Application No: FP/84/21/PL
Site Address: Land adjacent to The Gun Post Clyde Road Felpham PO22 7AH
Description of works: 1 No. additional self-contained beach hut with sleeping accommodation. This site is in CIL Zone 4 (Zero Rated) as other development.

Thank you for your internet representation made on 11th May 2021 which has been recorded as an objection with the comments as follows:

Street Scene

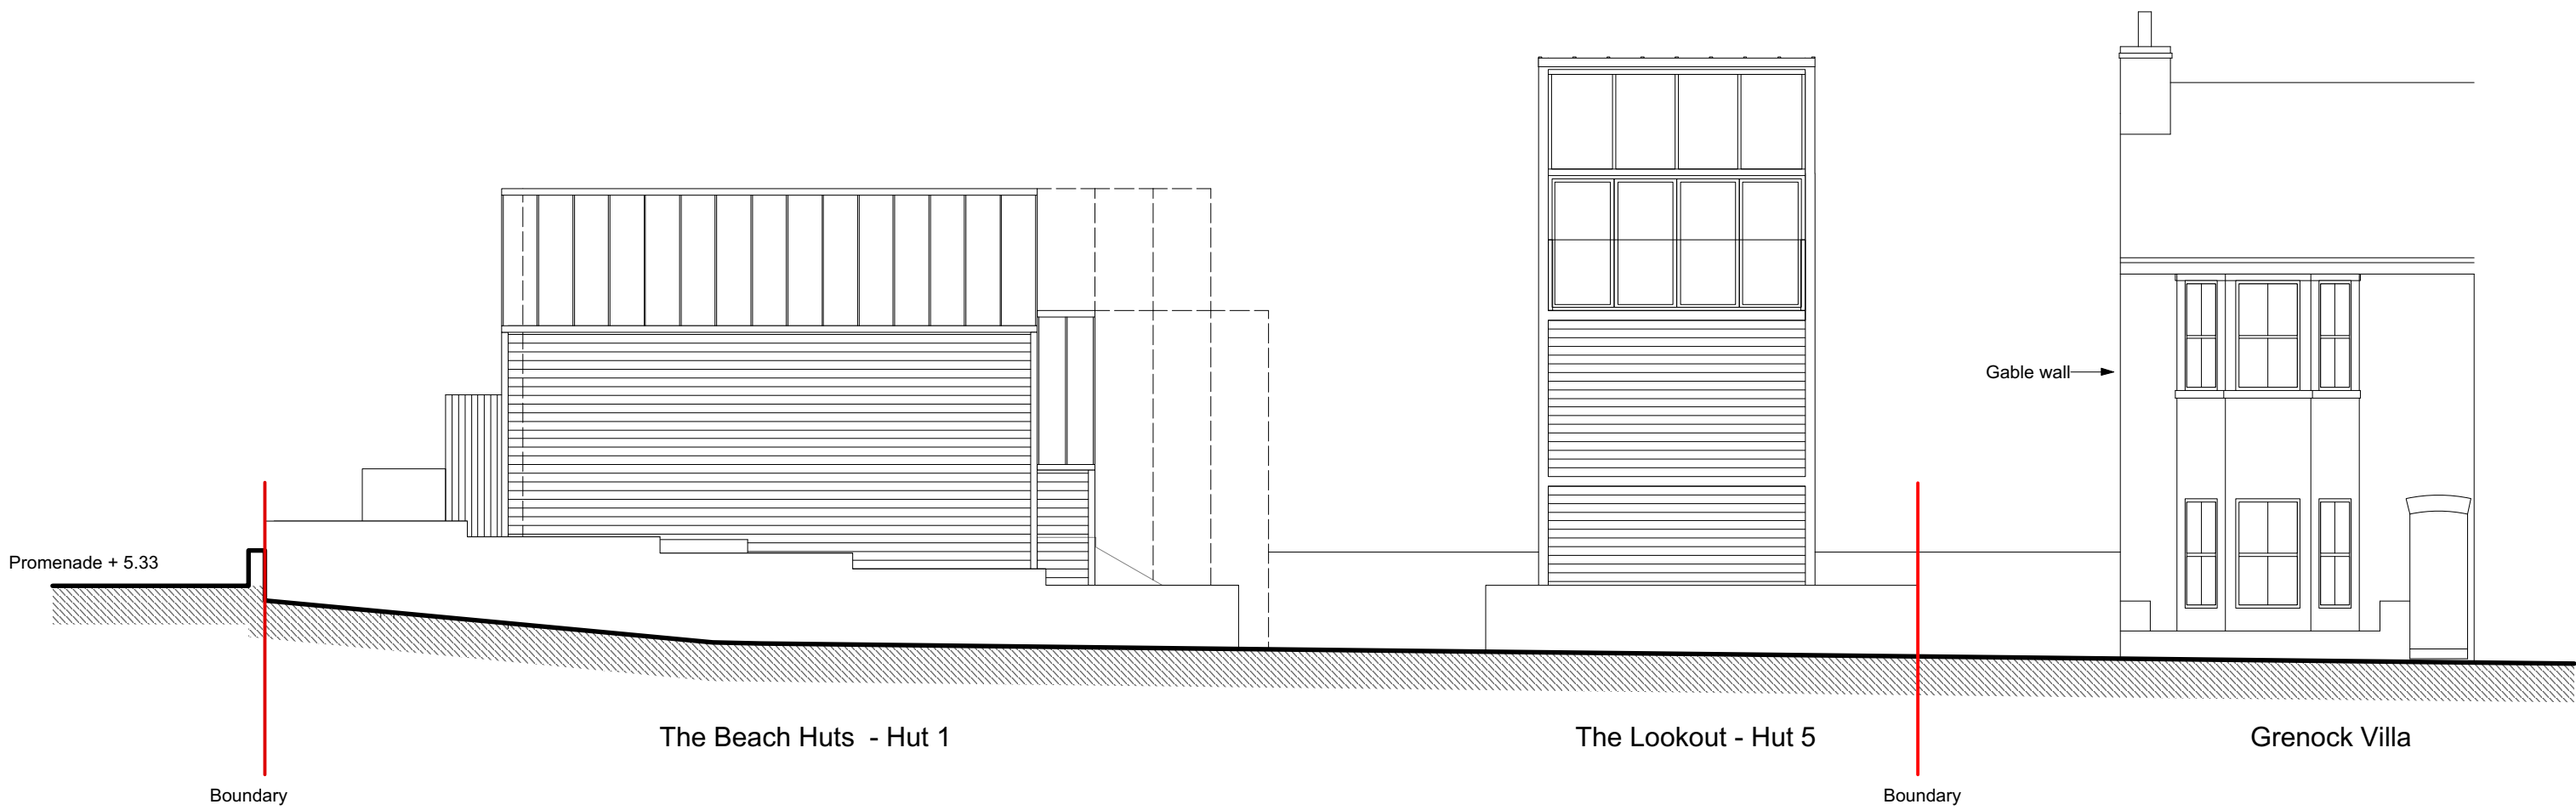
This is not a large site so this huge Beach Hut is over development, it is too high and some windows will overlook the property I live in! Also car parking looks limited as the turn around to the under hut spaces is going to be tight, people in the huts that are already there tend to park in the hotel. Ar park!
